RE: Constitution Storage Development; Full Spectrum Detention Pond Certification

Please accept this letter as formal documentation of conformance of the Full Spectrum Detention Pond (Pr. FSD-1) for stormwater quality and detention at the Constitution Storage Development. The Constitution Storage Development (Site) is located at 2460 Canada Drive, Colorado Springs within El Paso County, Colorado. The project site is located south of Constitution Avenue, west of Canada Drive, & east of Peterson Road. The site is located in a portion of Section 05, Township 14 South, Range 65 West of the 6<sup>th</sup> Principal Meridian, County of El Paso, State of Colorado.

MICROPOOL & OUTLET
 STRUCTURE DETAILS

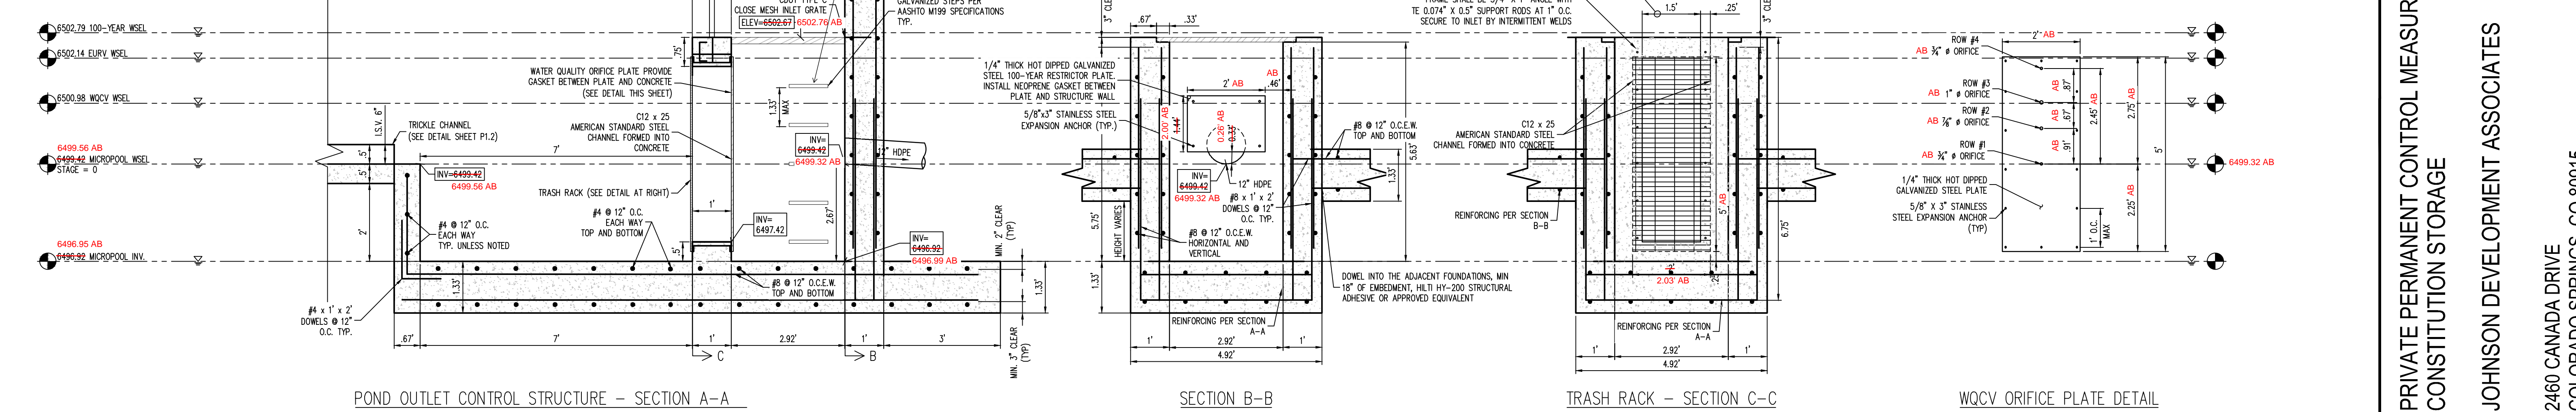
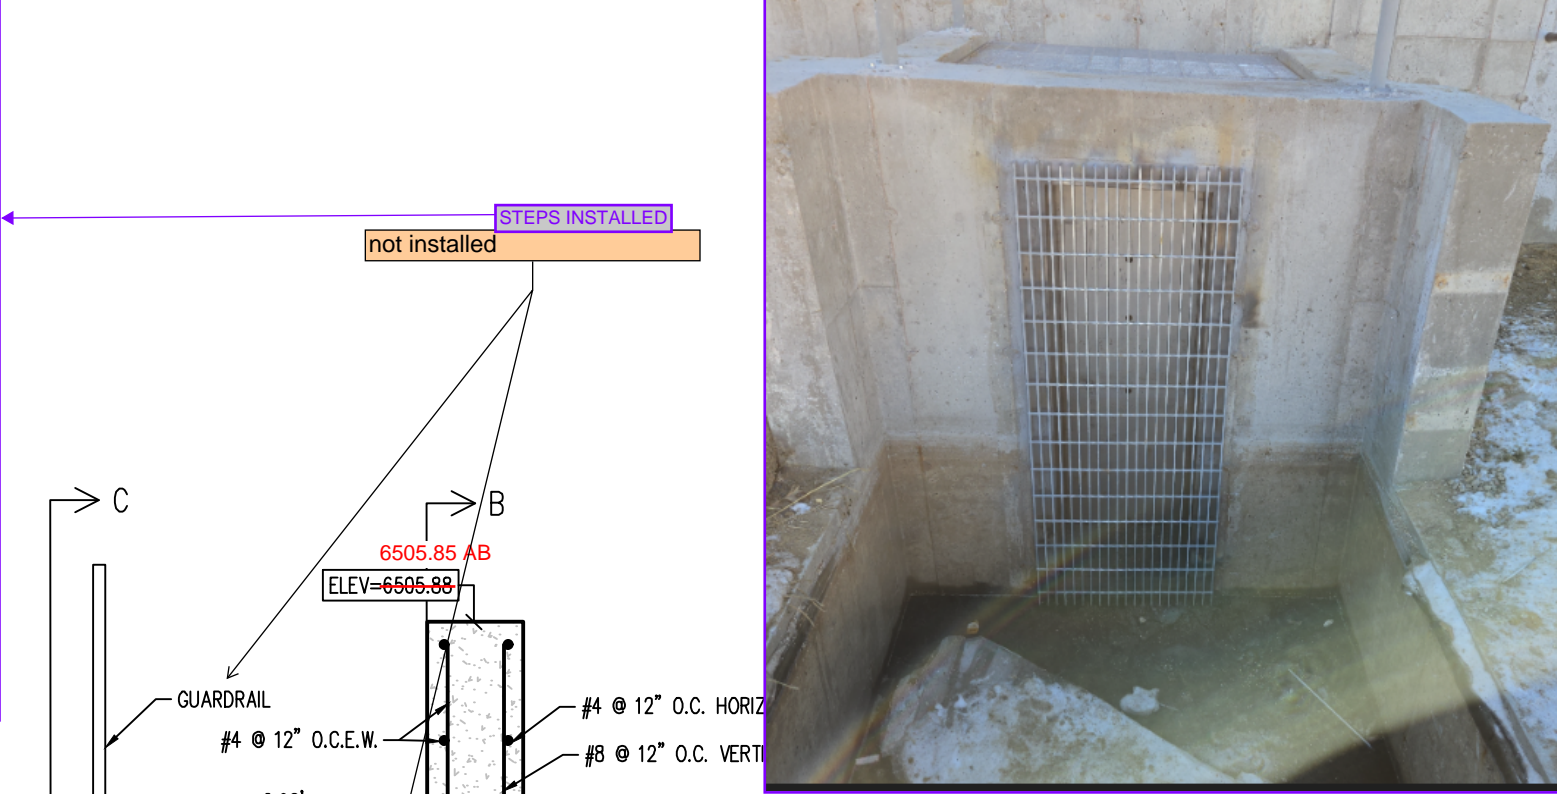
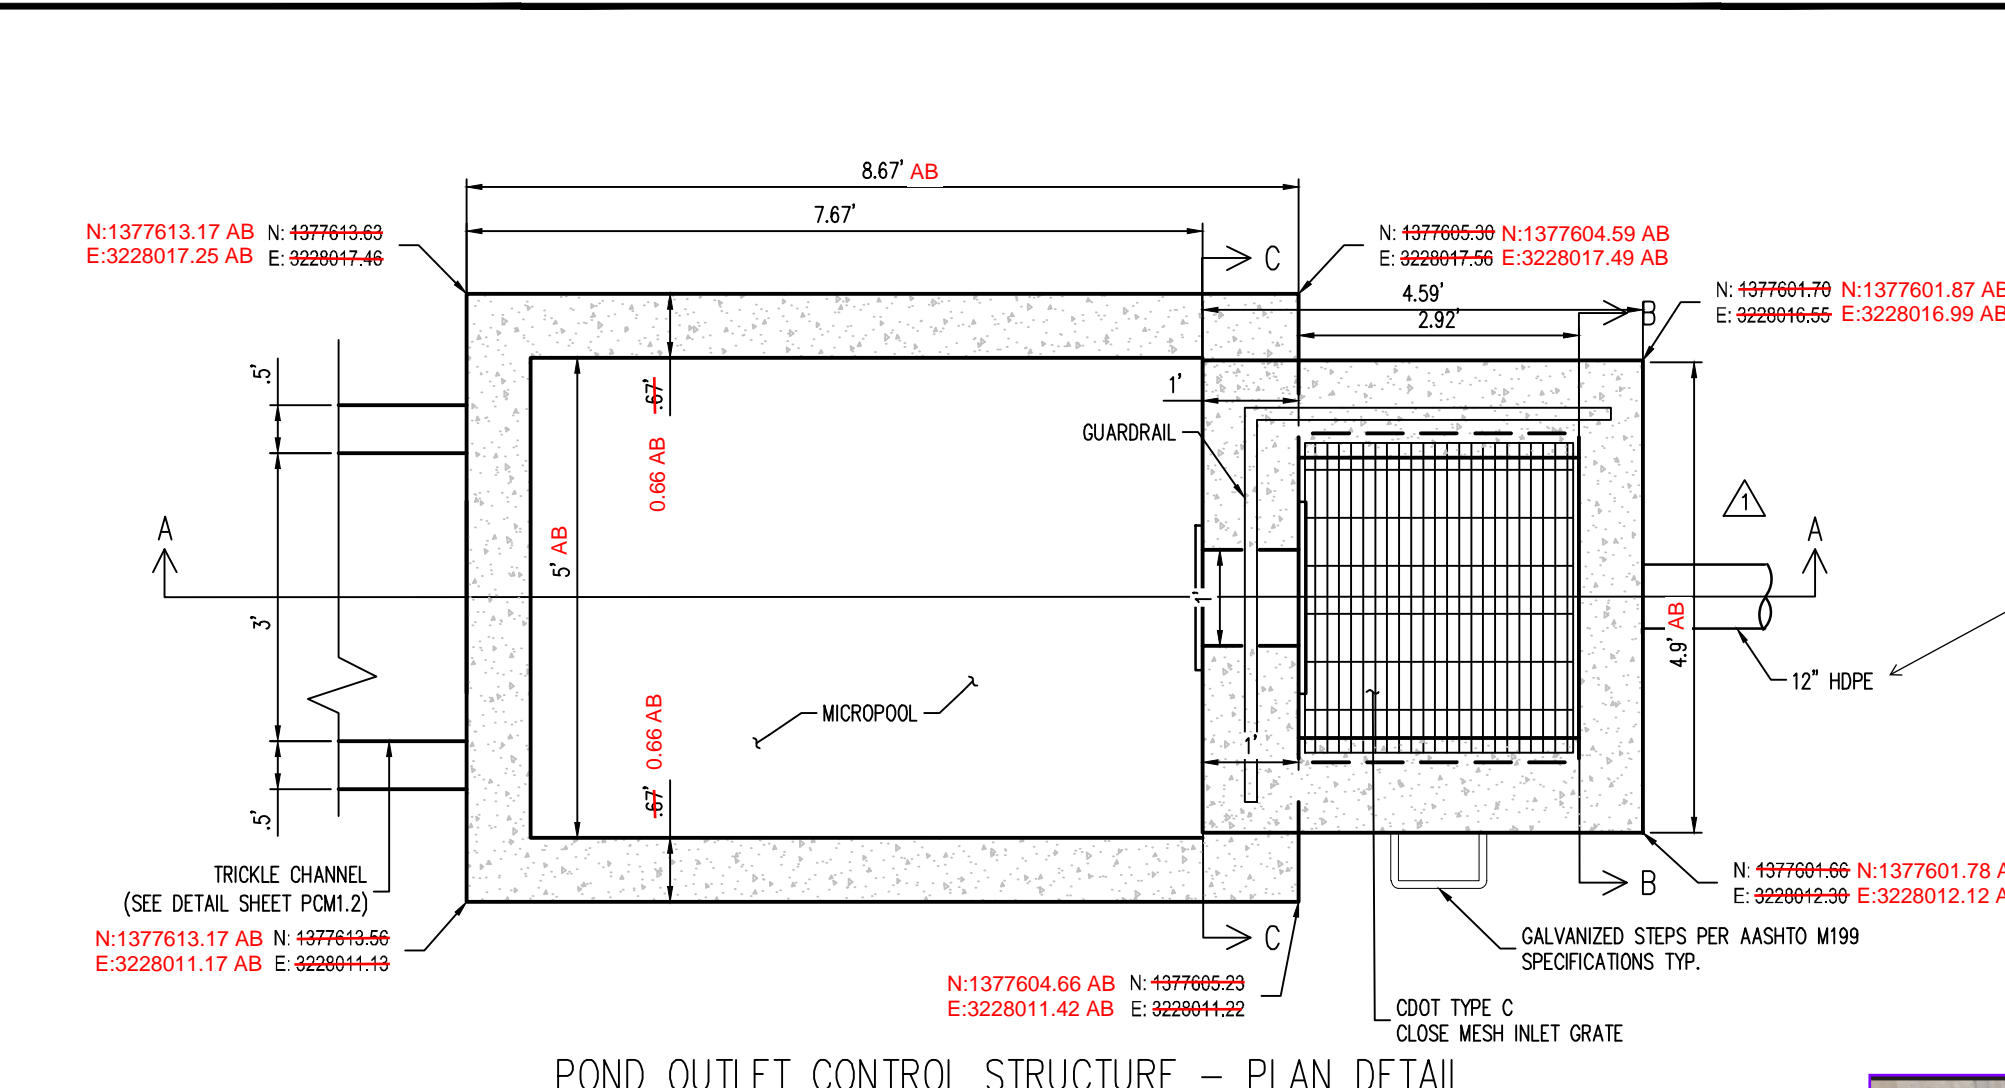
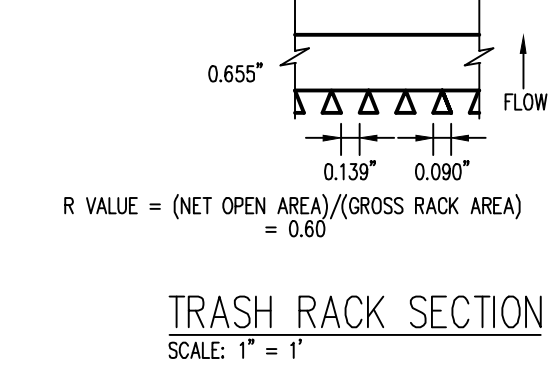
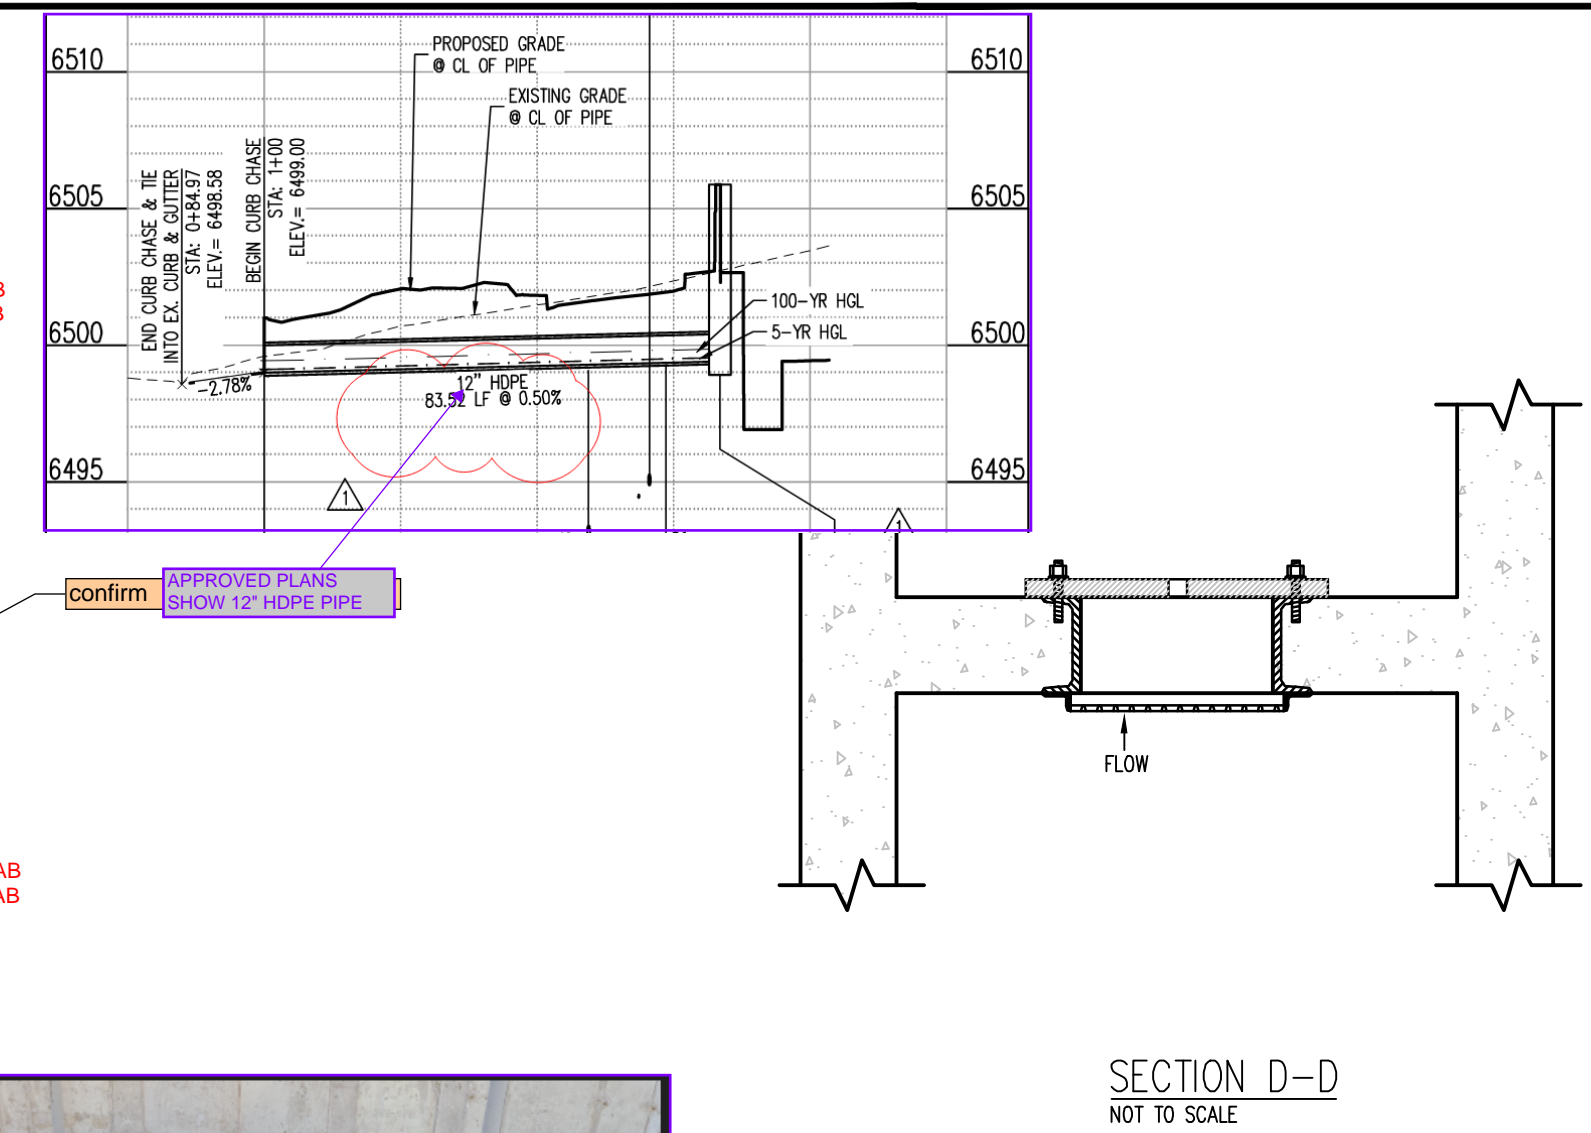
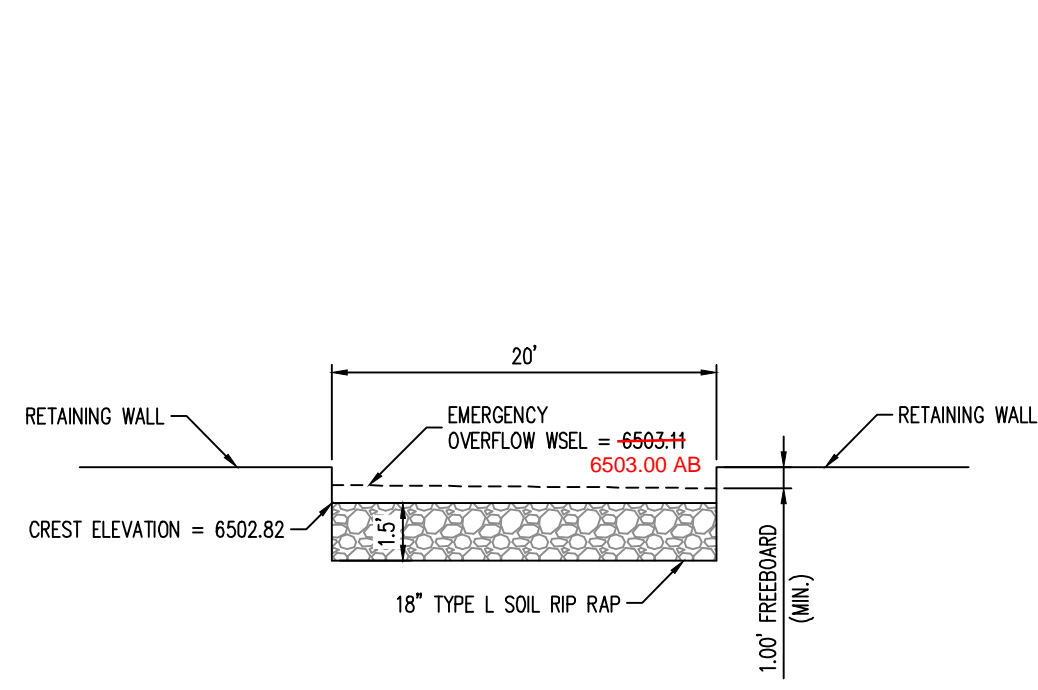
PPR2343 called for an 8" pipe. Please confirm
